aj/1128/WHBC/Obj/A

I am writing on behalf of the owner of n° 75 Pine Grove, Brookmans Park, Hatfield AL9 7BL to raise formal objections to the retrospective planning application (*planning ref: 6/2020/2857/FULL*)

The retrospective planning application is seeking to obtain planning permission for a variation to the original planning consent (*Planning ref: 6/2018/0215 FULL*) which permitted the erection of a pair of part single, part two storey semi-detached dwelling houses with landscaping/off street parking. The variations have been triggered by inaccurate survey drawings which resulted with the rear elevation extending further than envisaged beyond the rear elevations of immediate adjoining properties known as 71 and 75 Pine Grove. The partially implemented development is on hold pending the outcome of retrospective consent application

Drawing Number 73PG-11	Revision J
---------------------------	---------------

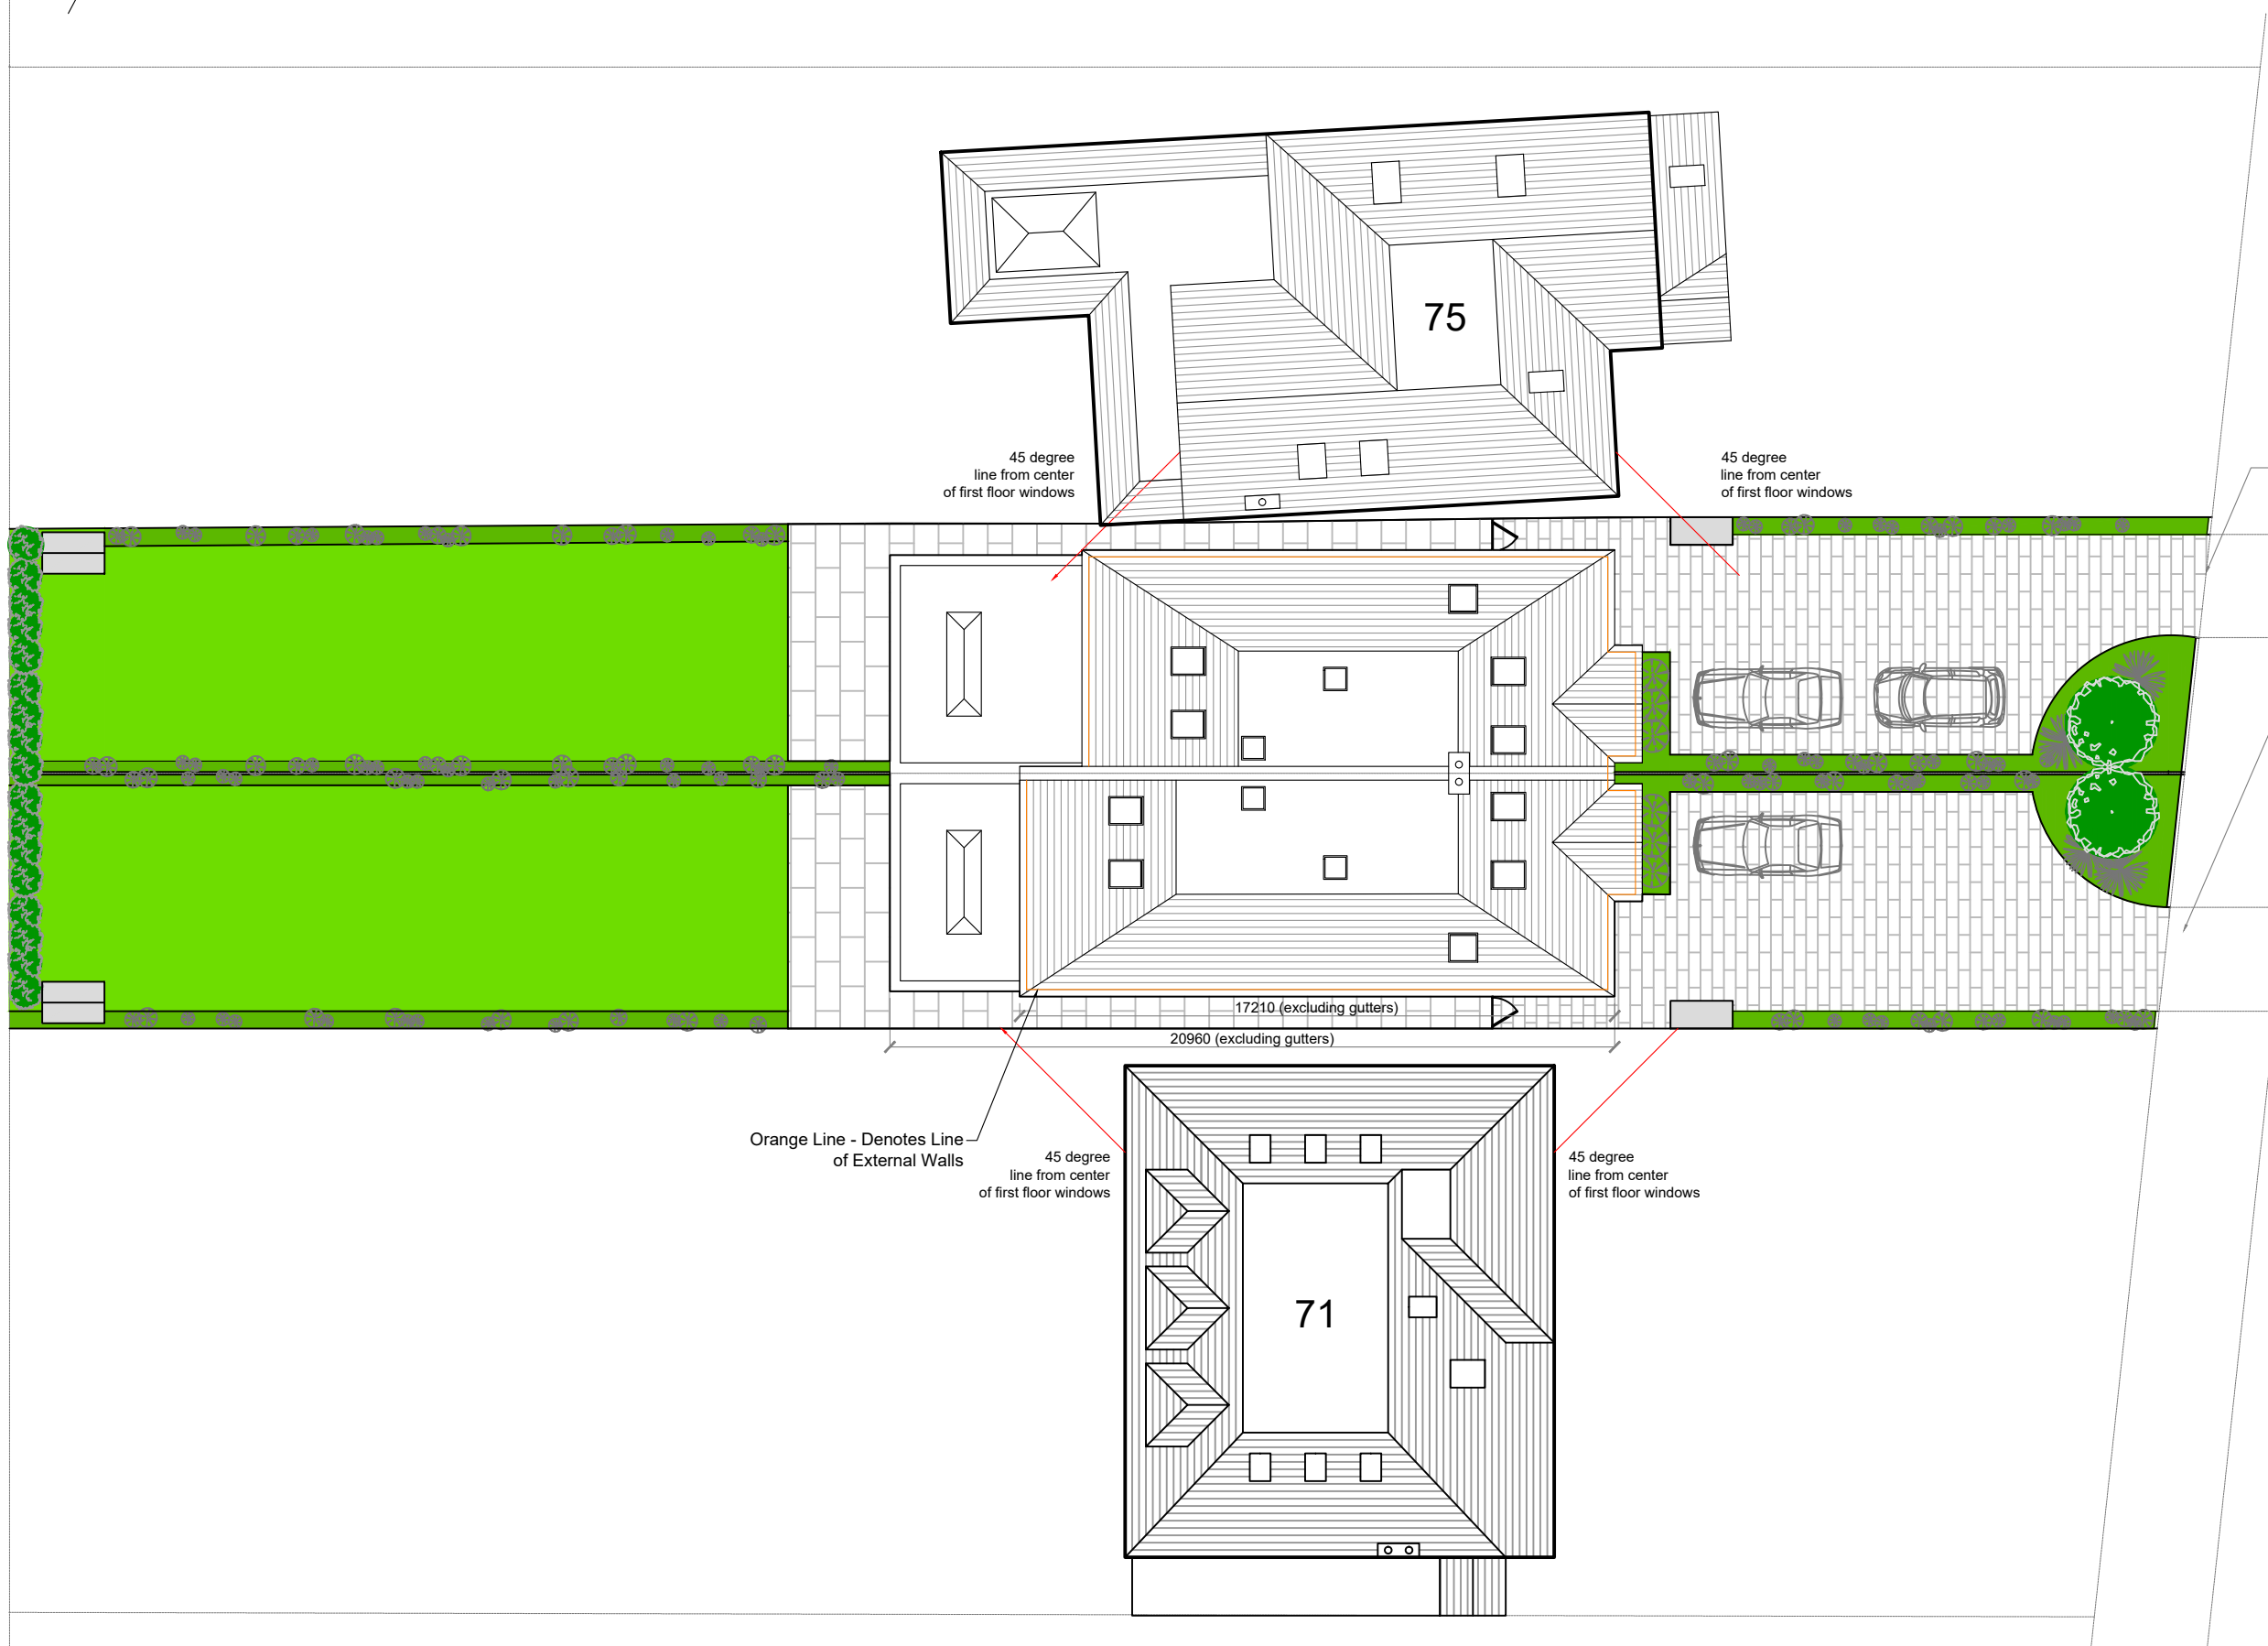
The 45 degree “line of sight” taken from the centre of the nearest adjoining property first floor window on drawing 73PG-11 rev “ J ” is incorrect as it does not consider the fact the rear elevation of n° 75 Pine Grove is angled 3° towards n° 73. This increases the calculated 1.8m set back by 300mm to 2.1m. (Refer to Fig 1.) .

Fig 1. Marked up extract planning application drawing 73PG-11 rev “J”

The first storey element should be set back at the very least by 2.1m as opposed to the offer of 1.8m with the added corroborated support of Sunlight and Daylighting calculations.
